From: Michael Eastham
Sent: 05 July 2017 17:21
To: Planning.Responses
Subject: FW: Fitzalan Link - LU.234.16.RES

In summary, there appear to be just three outstanding points now – the choice of road surface, the requirement for a new or supplementary Stage 1 Road Safety Audit and the design of the shared footpath-cycleway connection to Highdown Drive close to the new Toucan crossing now proposed. The other points can be tied-into the detailed S38/S278 submission.

Subject: Fitzalan Link - LU.234.16.RES

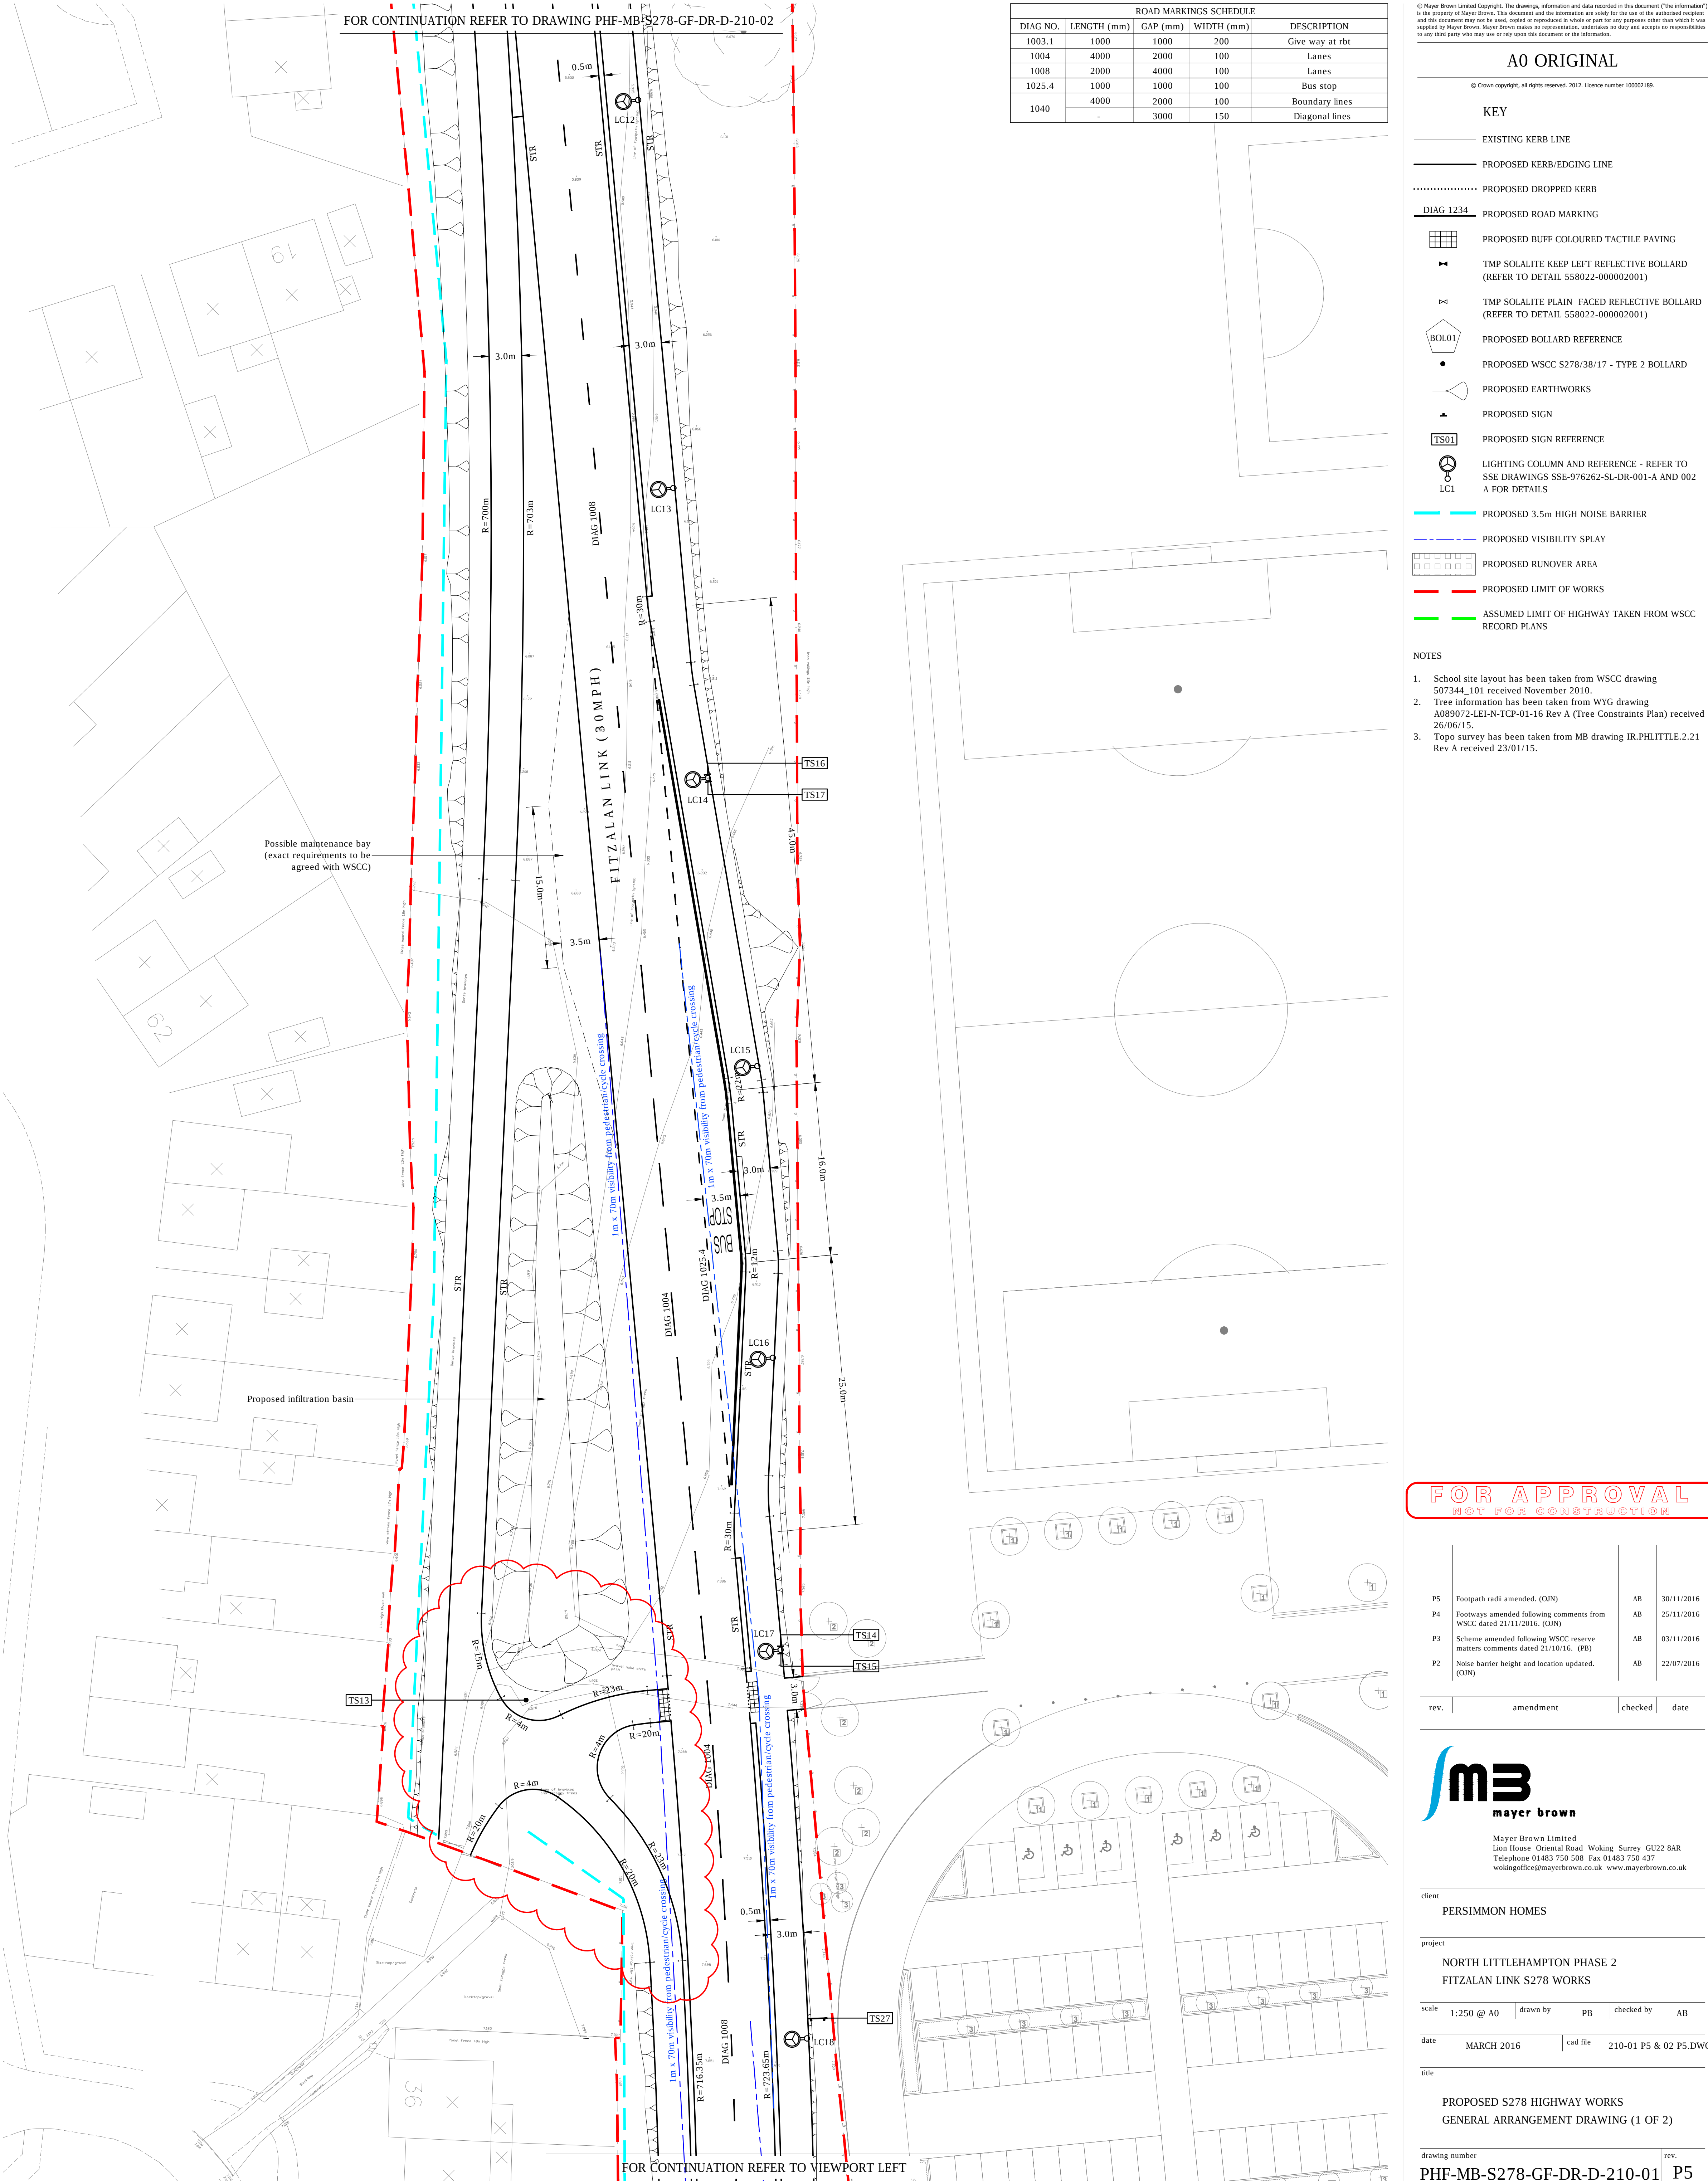
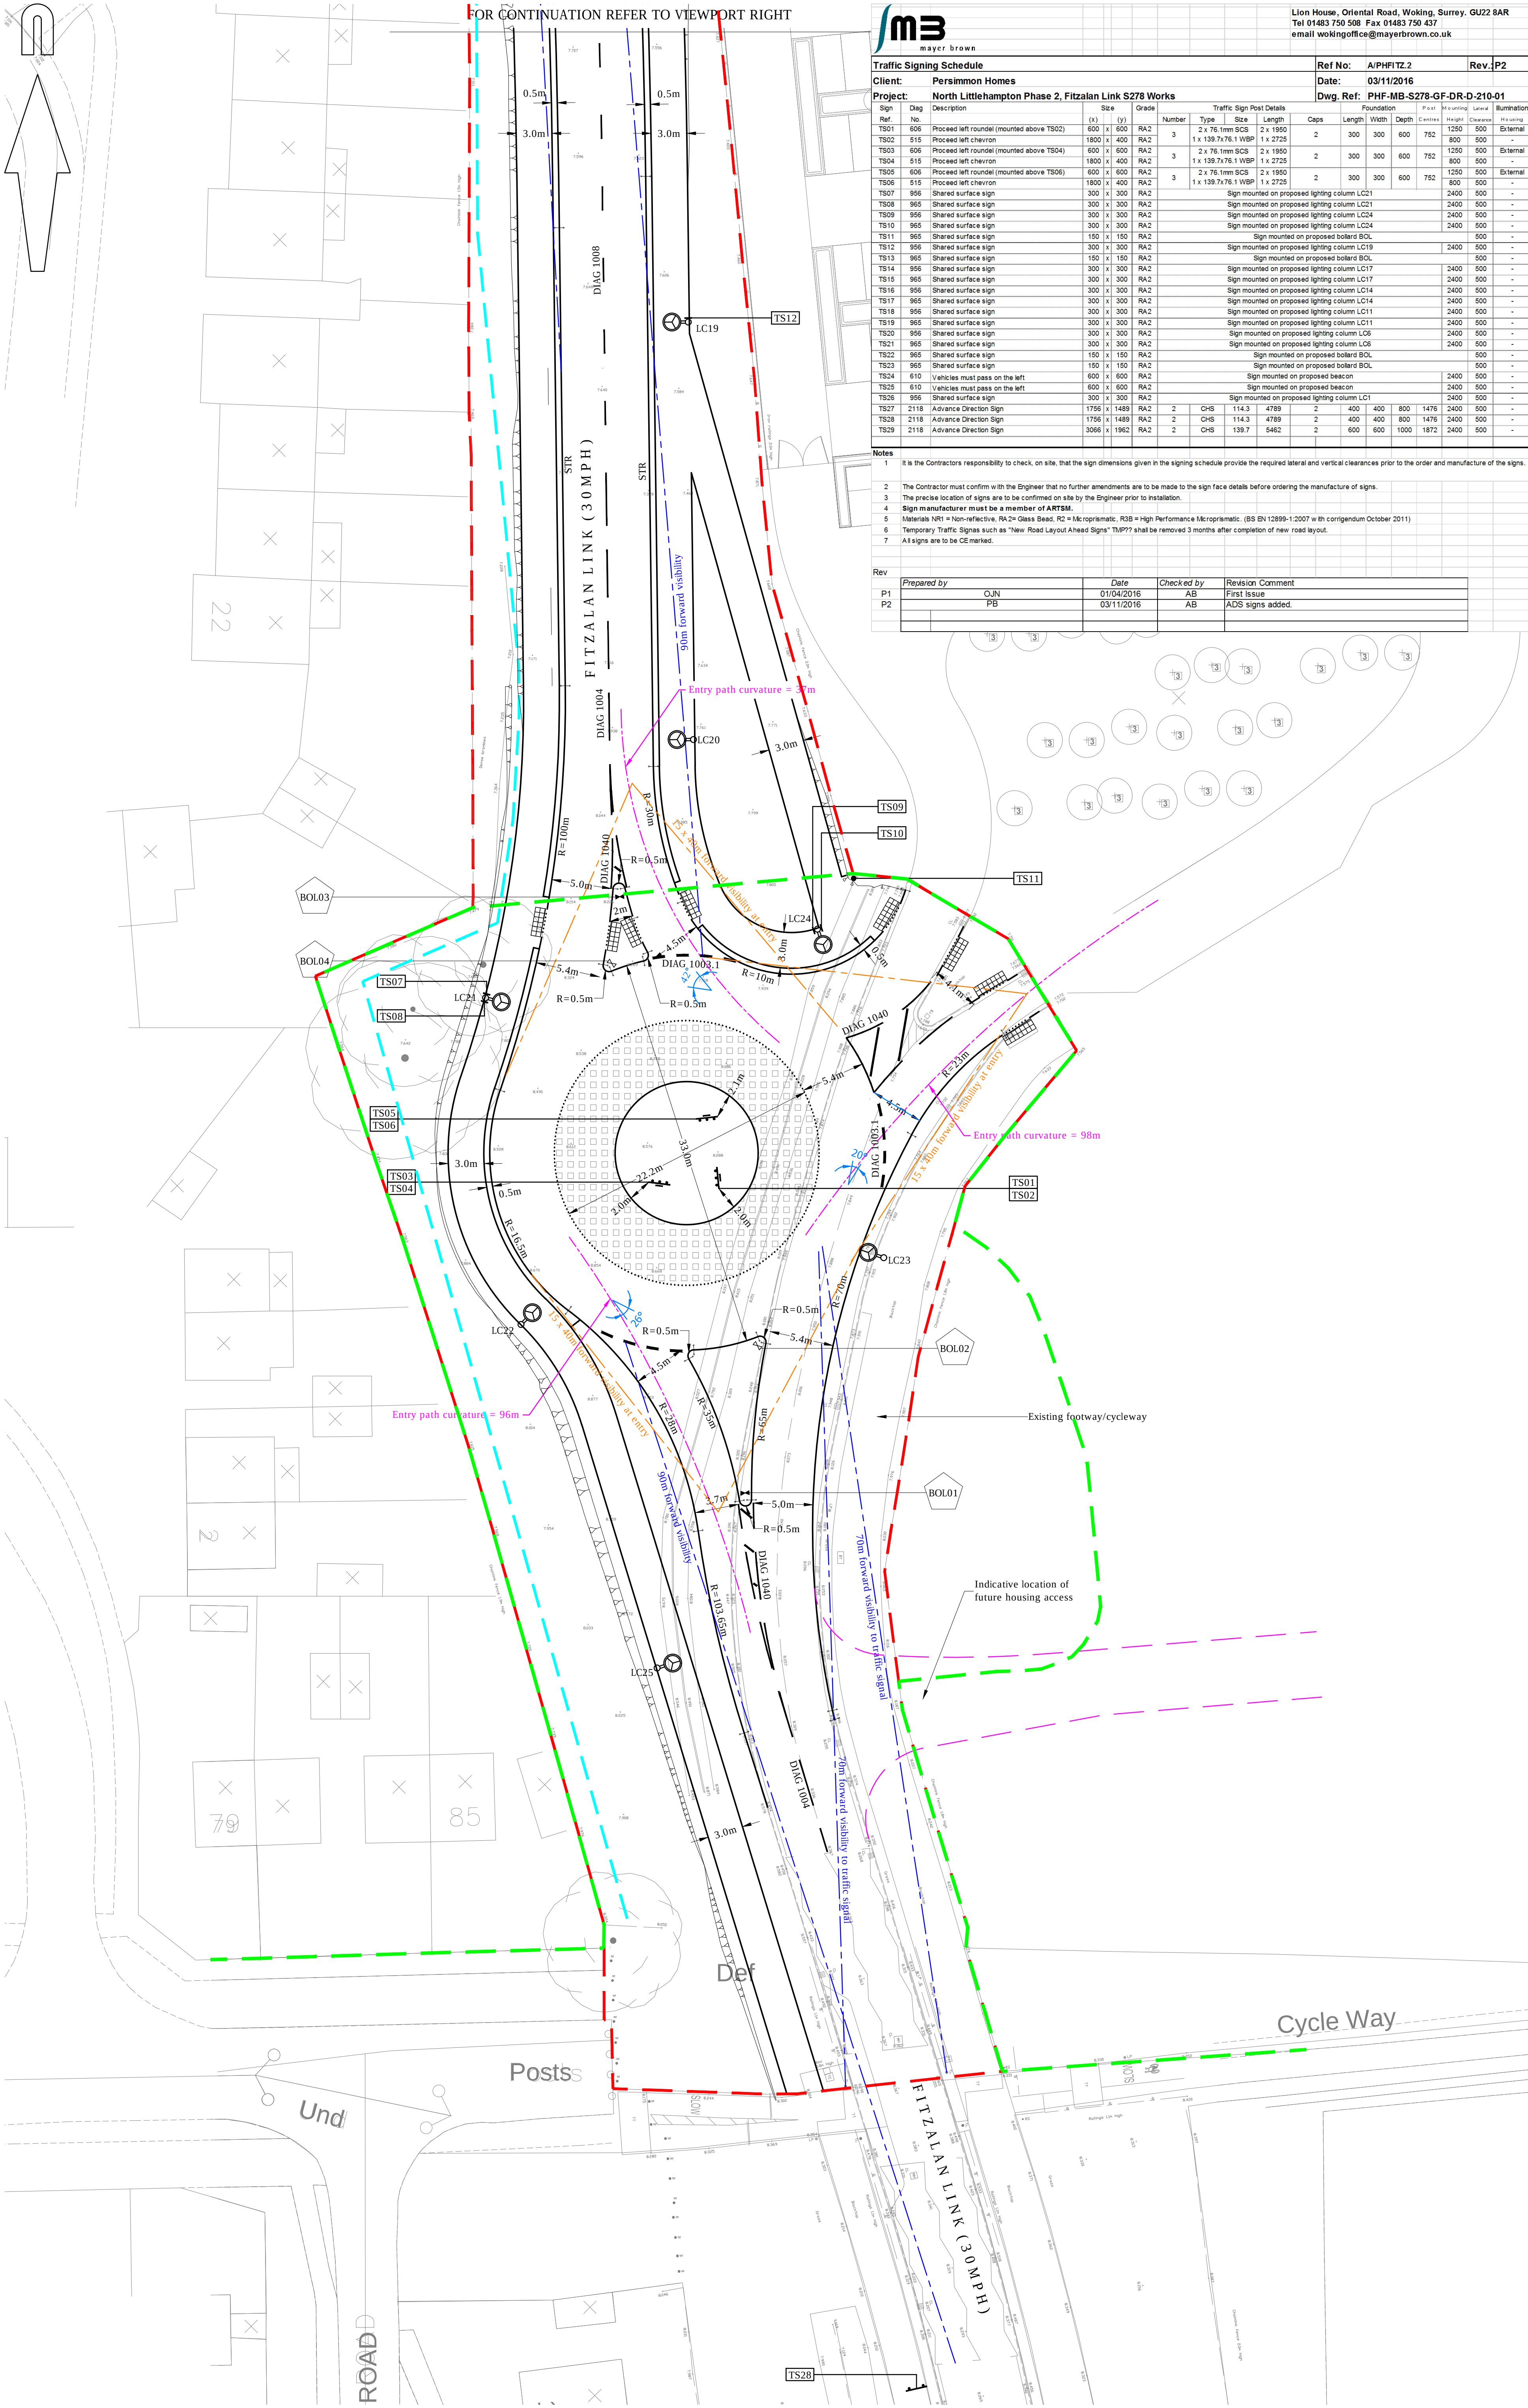
The drawings show a pervious road surface. This will not be long lasting enough. The best WSCC can consider is a negative textured road surface. However, this will not absorb as much noise. Your designer will need to look into "German SMA" which is an SMA with a high binder content and use an appropriate noise reduction factor.

Please provide a new or supplementary Stage 1 Road Safety Audit (and Designer's Response) that demonstrates consideration of all the changes shown on your drawings, please, from an independent road safety point of view. WSCC did raise the need for this in previous comments.

You have again offered an explanation for the path alignment in the vicinity of the Toucan crossing and balancing pond. The radii proposed are acceptable to us but the path must connect properly to the path leading to Highdown Drive which should be upgraded to a shared footway-cycleway. I have indicated below what this might look like. However, looking at this again shows the pink area to be public highway and on the line of part of Public Footpath 3103. Therefore, it is recommended (and indeed appears more straightforward) to retain this line otherwise it appears that any continuation of the route south of your scheme might cross land that might not be highway. Any path should be lit, edged, resurfaced, signed and tactile-paved appropriately although these final details can be shown at the S38/278 stage. Any upgrade from Public Footpath to shared footpath-cycleway must be undertaken in accordance with WSCC PROW procedures.

Academy roundabout northern traffic island has a tactile paved crossing point. Given that it is narrow (the tactile paving on the drawing appears to 'meet'), consideration should be given at the S38/S278 stage to widening it or adjusting the position of the tactile paving (if possible) to improve width for pedestrians. However, in doing this you should also ensure that the swept-path of vehicles can still adequately negotiate the roundabout without compromising safety for pedestrians on the island.

Recommend that at the detailed design stage, the cycleway on the east side be locally flared at the controlled crossing to provide additional width for waiting pedestrians and cyclists. Also, that LC 17 be moved to the very back of the space available, away from the area of conflict where there would be interaction between pedestrians and cyclists. WSCC recommended to increase the crossing width beyond the minimum so as to provide more space for waiting pedestrians in order to help keep the cycle route clear. The location of the control box must be carefully considered to avoid obstruction for users and visibility. Finally, it is recommended that corner radii be applied between the cycle paths at the school exit next to the crossing and that pedestrian and cycle intervisibility is provided at this location.

Thank you for showing a northbound bus stop and layby. Where possible (and again at the detailed design S38/S278 stage), additional path width should be provided at *both* bus stops to allow passengers to wait clear of the cycle path. Also, please consider where bus shelters might be placed, and what form these would take given the space available.

We sought to reduce carriageway of the road to 6.75m as this would have the effect of constraining speed closer to the proposed 40mph speed limit requested by WSCC. As a result, HRA (standard surface) could be provided. Our noise consultants have assessed the impact on noise relating to a speed limit of 40mph and with a HRA surface course finish (standard / noisiest surface) and this includes that speeds of 42mph would be okay in terms of the noise assessment submitted and enable a 3.5m noise barrier to provide sufficient noise mitigation. WSCC's 2010 speed policy refers to an average speed of 42mph for a 40mph road. Thus the above would appear appropriate. The CHA is satisfied with this now – details to be checked at S38/278 stage.

A Stage 1 RSA Addendum will be provided once the layout is agreed in principle. When the PROW connection has been shown correctly on an amended drawing (see comments below), and showing the overall Fitzalan Link Road scheme and the changes already undertaken, Persimmon must undertake a new or Supplementary Stage 1 Road Safety Audit and Designer's Response thereto. WSCC will then review those documents. **The Stage 1 Safety Audit process must be concluded before determination of the application.**

The highway boundary plan and alignment of the existing PROW is noted. However, this is not evident on the ground since the Academy has been constructed (see extract from Google Earth below). We can show the alignment requested, (based on the OS Highway Boundary plans provided) but we would only have the power to construct the pathway up to our limit of ownership (the red line). WSCC has less than Freehold rights beyond the red dashed line and as such we don't believe we would have any power to undertake works on this area of land (see attached) to effect the PROW route beyond the red line, hence the reason for showing the tie-in (at the limit of ownership) to the existing physical route present on the ground. Therefore, we believe that what we have shown on the submitted drawings is the best solution, unless WSCC can confirm that we could legally obtain power to undertake works on land that they don't have complete freehold rights over. The legal line of the highway south of the Persimmon land is as shown in pink of the extract found below taken from my earlier email of 24th May 2017. As such, this is the line that should be used. As such, Persimmon should show their connection to the point shown on their boundary to ensure appropriate connection with the correct alignment. Persimmon to provide appropriate signage, lining, tactiles etc.

Noted. We shall review to see what changes can be made to accommodate a larger island as requested. Noted.

Noted. We shall review to see what changes can be made. Noted.

We have been clear that space is restricted to provide this late edition facility (which we are doing to accommodate an WSCC oversight on the section of the Link Road they have already delivered) . We 'may' be able to provide an increased width footway of 3.5m on the western side, but we will need to review the levels so this can not be guaranteed and should not be used as a means to hold up this application. Otherwise, if the footpath width is crucial then we will not be able to provide a bus stop at all. In terms of bus shelters we can provide one but is likely to restrict foot / cycle path width even more. Furthermore, this seems a bit onerous given that the outline doesn't actually require us to provide a bus stop. We consider that an open bus stop is appropriate, especially given the width restriction and if a shelter becomes necessary at a later stage WSCC could fund this with wider infrastructure contributions. As stated previously, details will be reviewed at the S38/278 stage.
